A303 Stonehenge; Amesbury to Berwick Down

Proposed application for development consent order

Consultation response of the Trail Riders' Fellowship

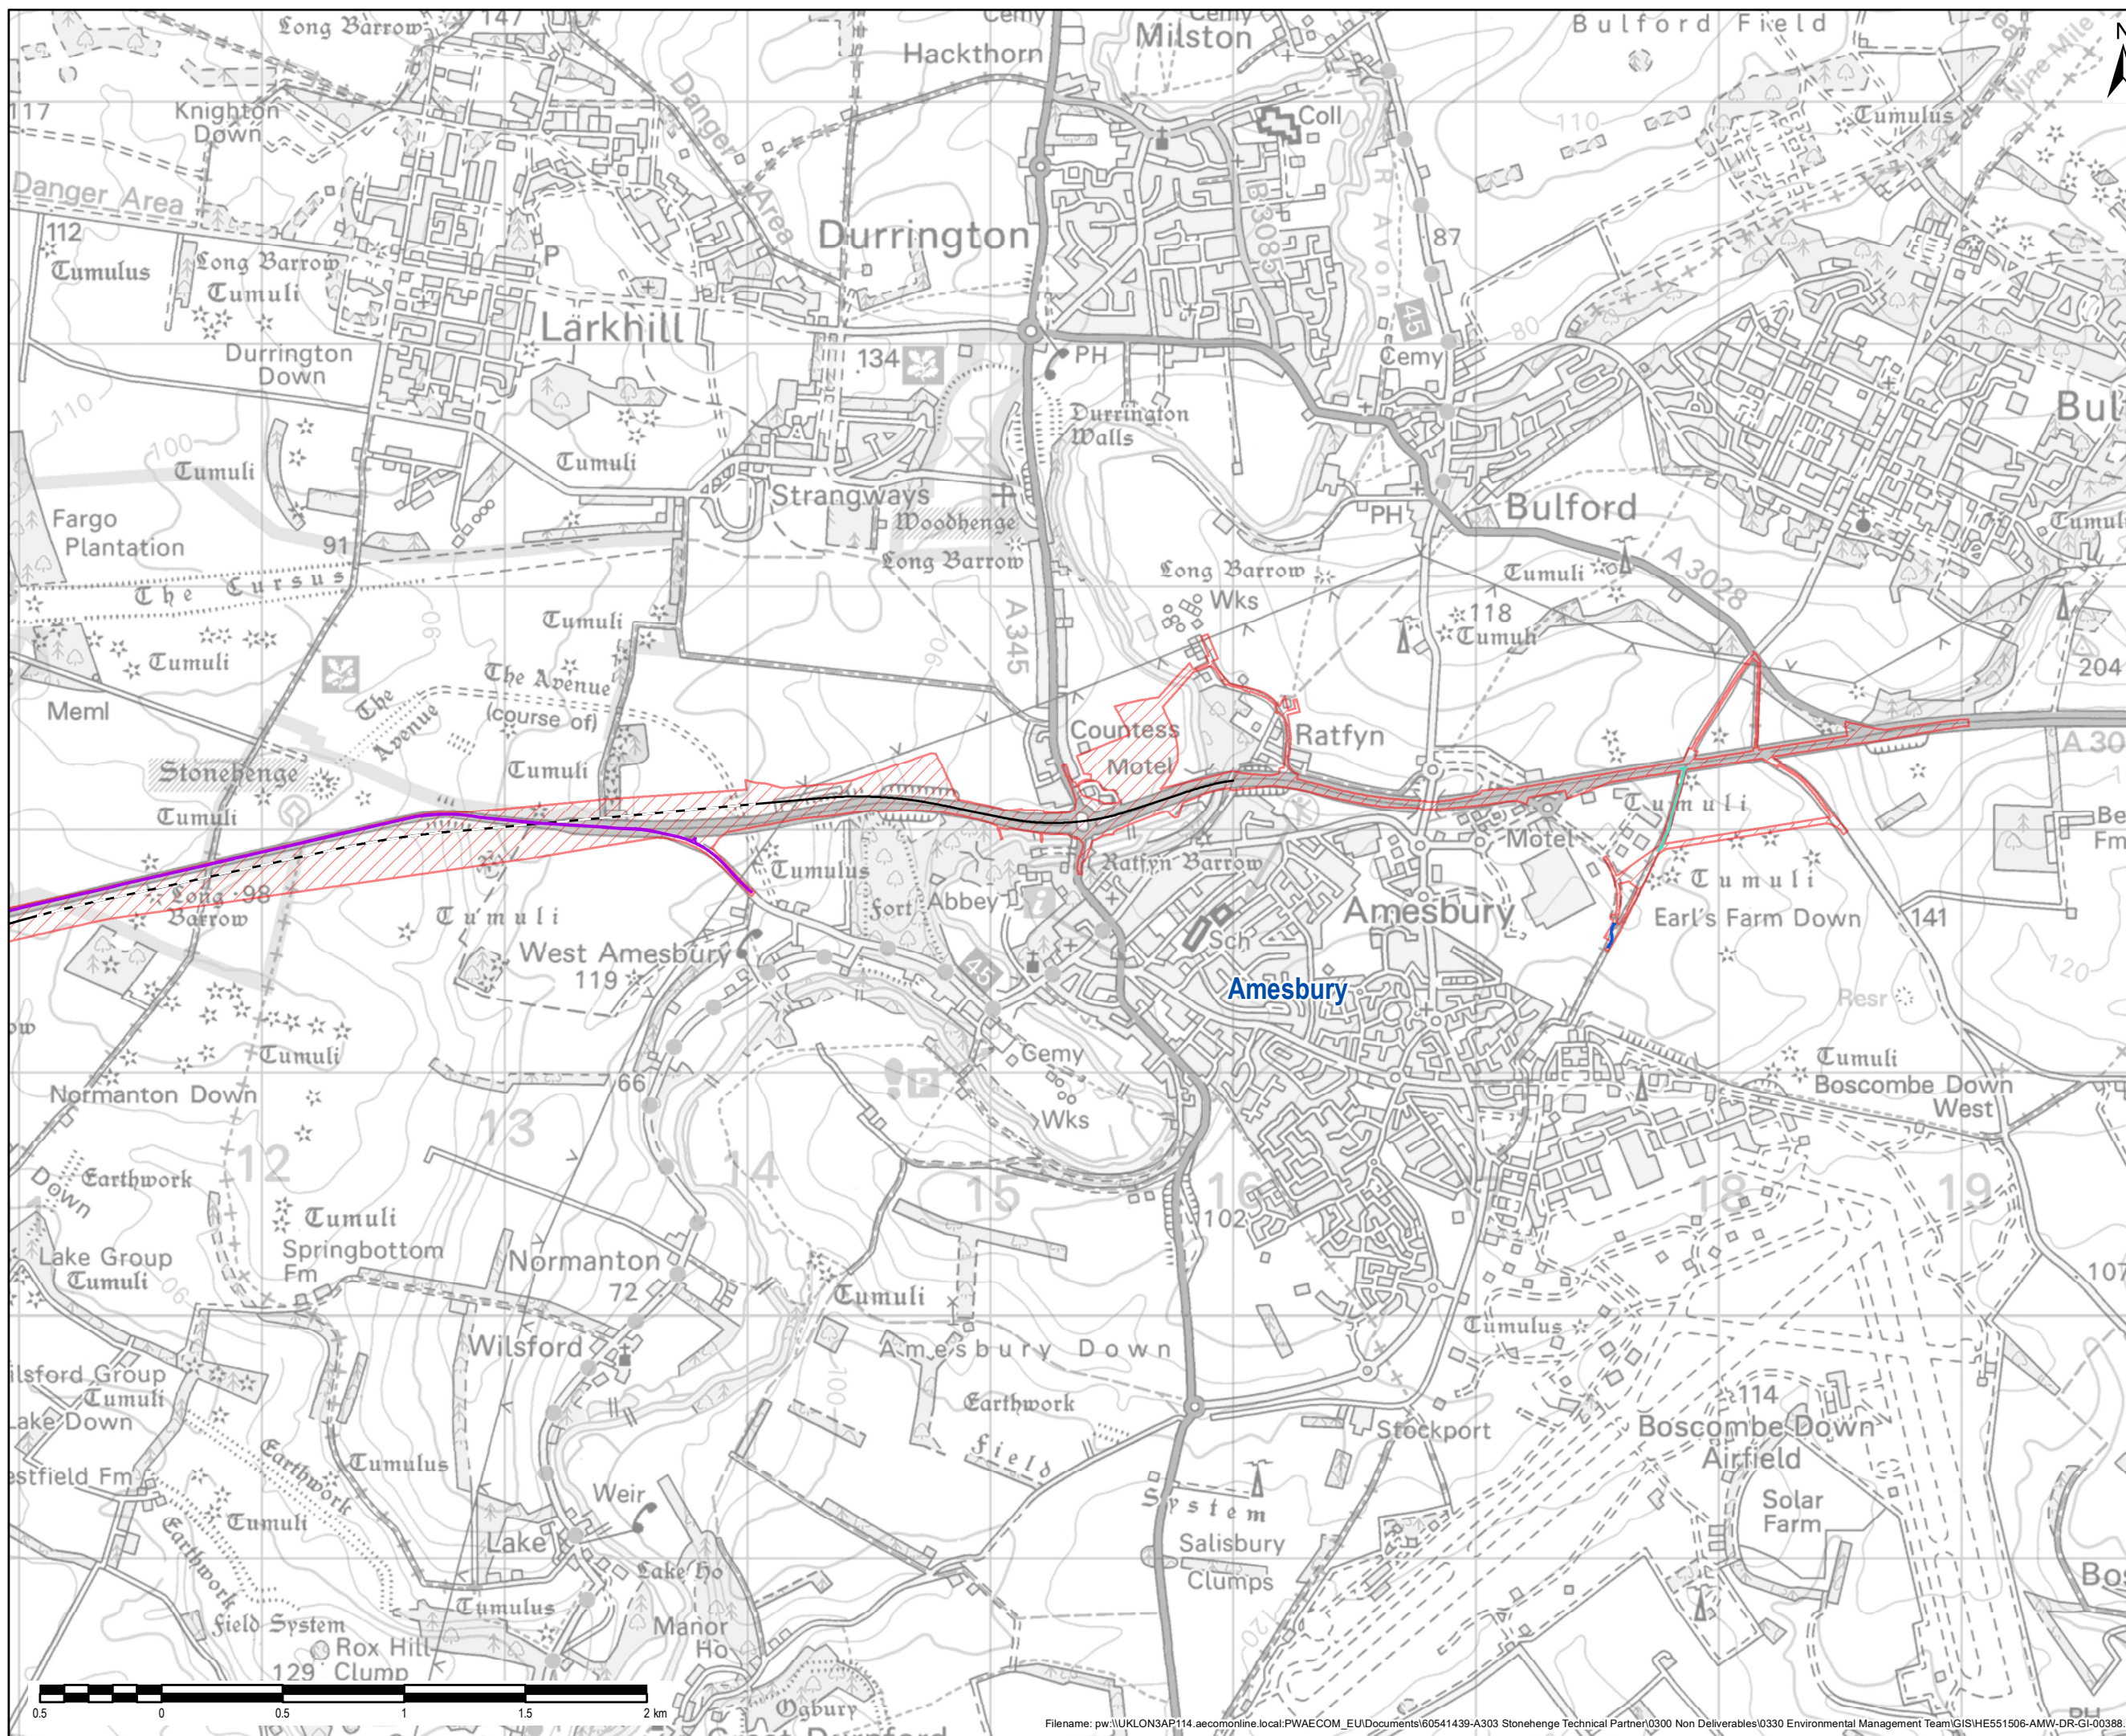
3. The part of the scheme that concerns TRF is set out in the drawing in the Consultation Booklet as Figure 5:16: The central section – within the World Heritage Site (WHS). This drawing shows Byway 11 and Byway 12 being cut-back southwards from their current junctions with the A303, and connected by a "New Link Between Byway 11 and 12".

5. However, TRF has the following concerns about other aspects of the proposal:
 - a. firstly, given that the new route will exclude small-capacity powered two-wheeled vehicles, the proposed byway mainly on the at-grade line of the A303 should be available to this limited class of vehicle.

8. In this case, the proposal is to extinguish the A303 for certain categories of user and by converting that road into a tunnel, to extinguish the historic connection between Byways 11 and 12, leaving Byway 11 in particular as a dead-end.

12. The proposal would remove the historic link between Byways 11 and 12 because the existing A303 would be converted to a restricted byway and the new A303 would be underground. However, the provision of a new linking BOAT to the south would prevent the connection being lost and would prevent Byway 11 becoming a dead-end. TRF therefore does not object to this aspect of the proposal.

13. It seems to us that the proposed new link between Byway 11 and Byway 12 would be physically suitable for light traffic. A motorcycle and rider together are considerably lighter than a horse and rider. There is no history of, and little if any visual evidence of, surface impact from motorcycles on Byways 11 and 12. Some form of restricted byway for horses, cyclists, carriage drivers, and walkers, would be as much a 'track on the land' as would a Byway with a right of passage for motorcyclists.

18. The alternative route proposals bite against the users of mopeds, electric mopeds, and motorcycles under 50cc. These drivers have an expectation that their safety and amenity will be reasonably protected.
19. Electric mopeds are virtually silent in use and often physically resemble a mountain bike, but cannot lawfully be driven on a restricted byway or bridleway. The alternative route is adequate in the sense that you can get from A – B, however, a moped (petrol or electric) rider would be exposed to the greater hazard of using an A road instead of a safer BOAT. The additional distance (twice as far on the diversion as on the current line) is a factor in terms of battery range for the electric moped. It is also physically and mentally taxing to ride a moped on fast A roads, for a

20. The fact that the proposed restricted byway along the line of the old A303 will be available to emergency vehicles demonstrates that it will be more than adequate to carry small powered two-wheelers.
